SSD_7417: REGIMENT MIXED-USE REDEVELOPMENT, UNIVERSITY OF SYDNEY, DARLINGTON CAMPUS

UNIVERSITY OF SYDNEY RESPONSE TO SUBMISSIONS

18 MAY 2017

Accessible Unit Plans	10107_DA055	1
------------------------------	--------------------	----------

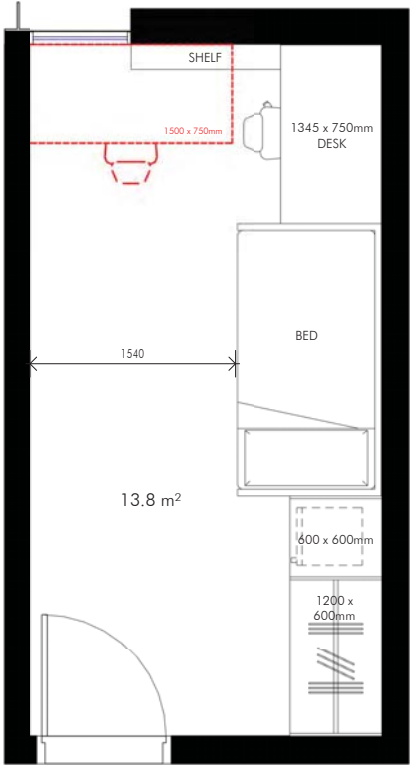
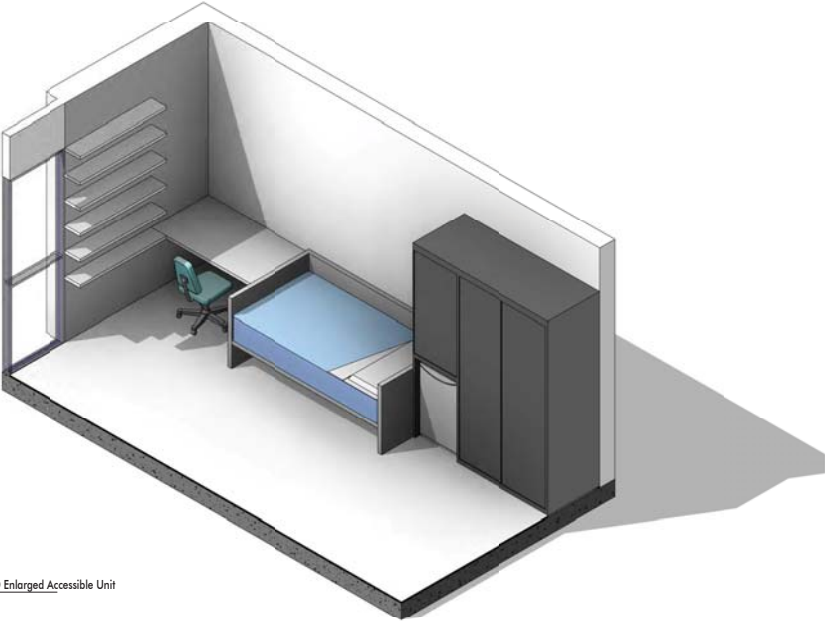
c) accessible rooms should be located adjacent to the lift cores;	<p>Agreed: However, accessible rooms should not be grouped together as this will be perceived as inequitable and discriminatory. Furthermore, there is no statutory requirement to locate the accessible rooms close to the lift cores. Notwithstanding, the Regiment proposal has been amended, as documented in Attachment 1.02, to provide that:</p> <ul style="list-style-type: none"> • a greater number of accessible bedrooms are relocated close to the lift cores. The attached plans illustrate by colour code those accessible rooms proposed for relocation; and • accessible rooms should be located close to the refuge areas (located in the fire stair wells).

Section B
1 : 200

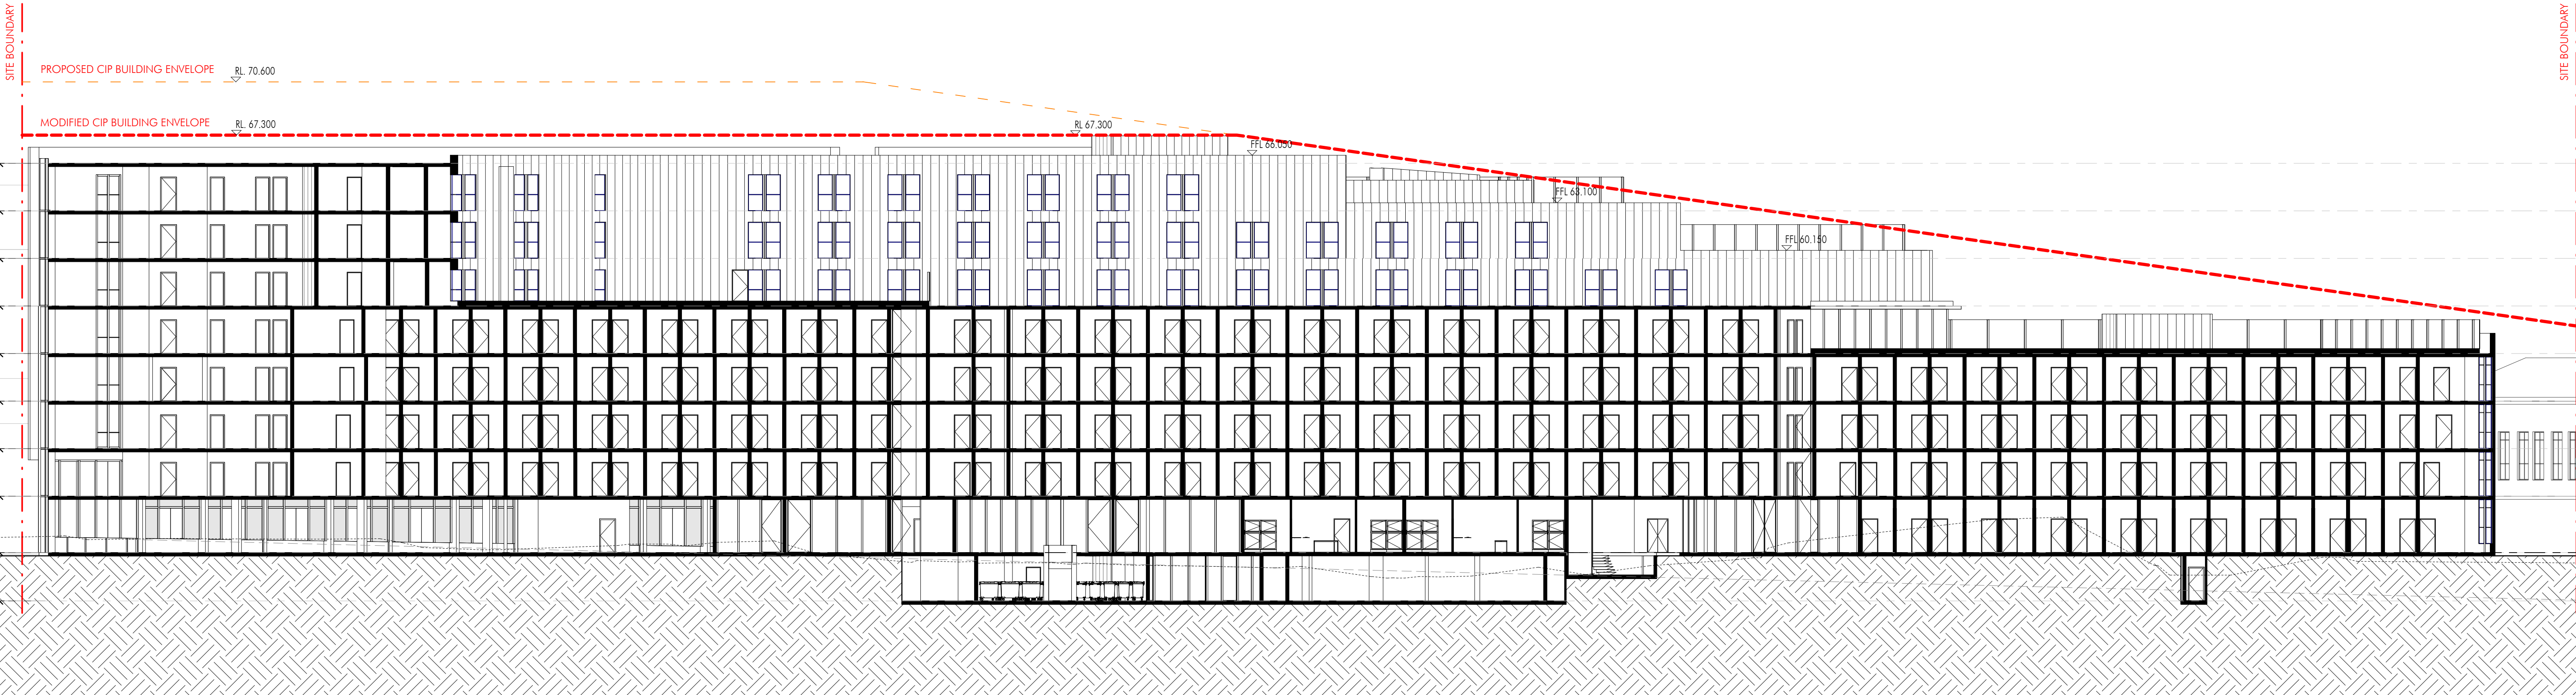
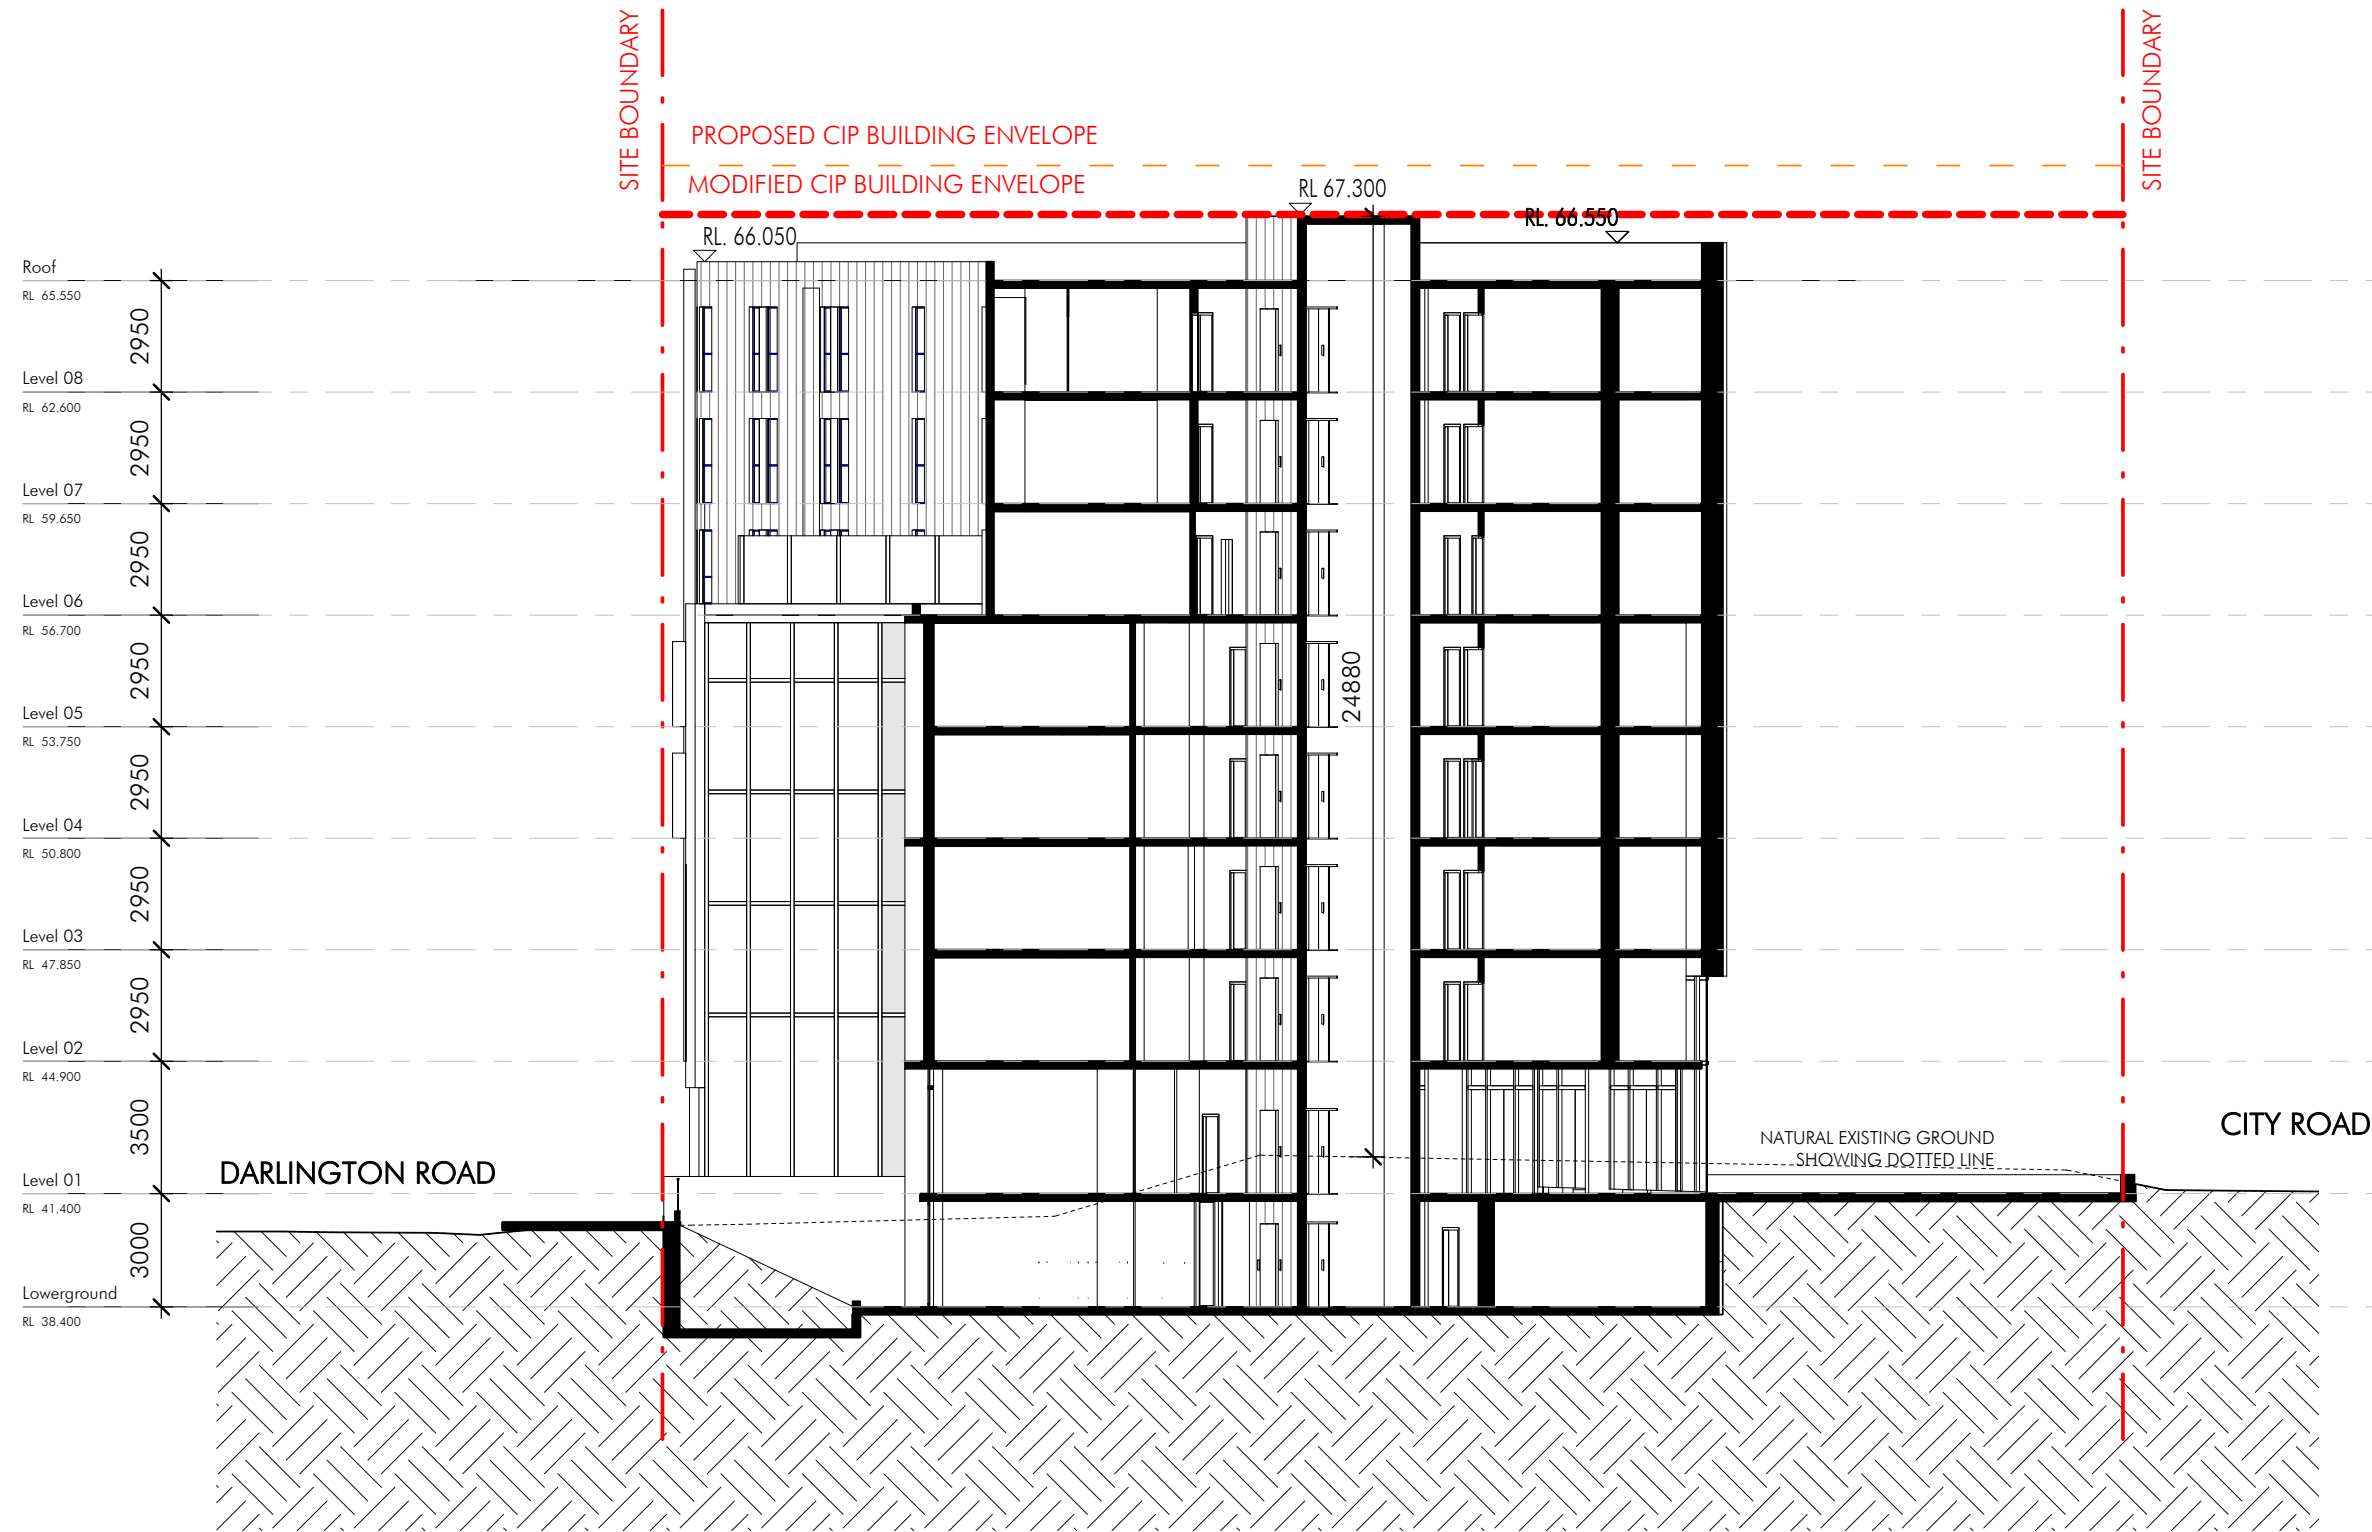
f) solar screens should be provided to windows to reduce heat load, particularly for rooms that are north and west facing;	<p>Disagree: Solar screens will not be provided to windows as the existing treatment of the windows has been designed to manage heat loads especially to north and west facing dorm rooms.</p> <p>The design incorporates 400mm deep set paired apartment windows that provide integrated self-shading to the glazing, the sides and top overhang of the typical room window. Shading is also provided by the overhang at level 3 shading level 2 rooms. See below extracts from the architectural design report and drawings that demonstrates the self-shading design of the windows (refer to page 57 page the Architectural Design Report. Image of intent – extract provided below).</p> <div data-bbox="1567 793 2677 1249" data-label="Image">  </div> <p>(Refer to DA 025 that shows circa 400mm overhang to level 2 room windows).</p> <p>Furthermore, between the pair of windows a 200mm projecting metal fin will be incorporated to provide additional sun-shading and articulation to the façade (refer to page 38 of the Architectural Design Report which shows the 200mm projecting fin at the end of the party wall - image extract provided below):</p>

An extract of drawing DA025 Section 1 below illustrates the vertical fins shaded dark grey and casting shadows in elevation:
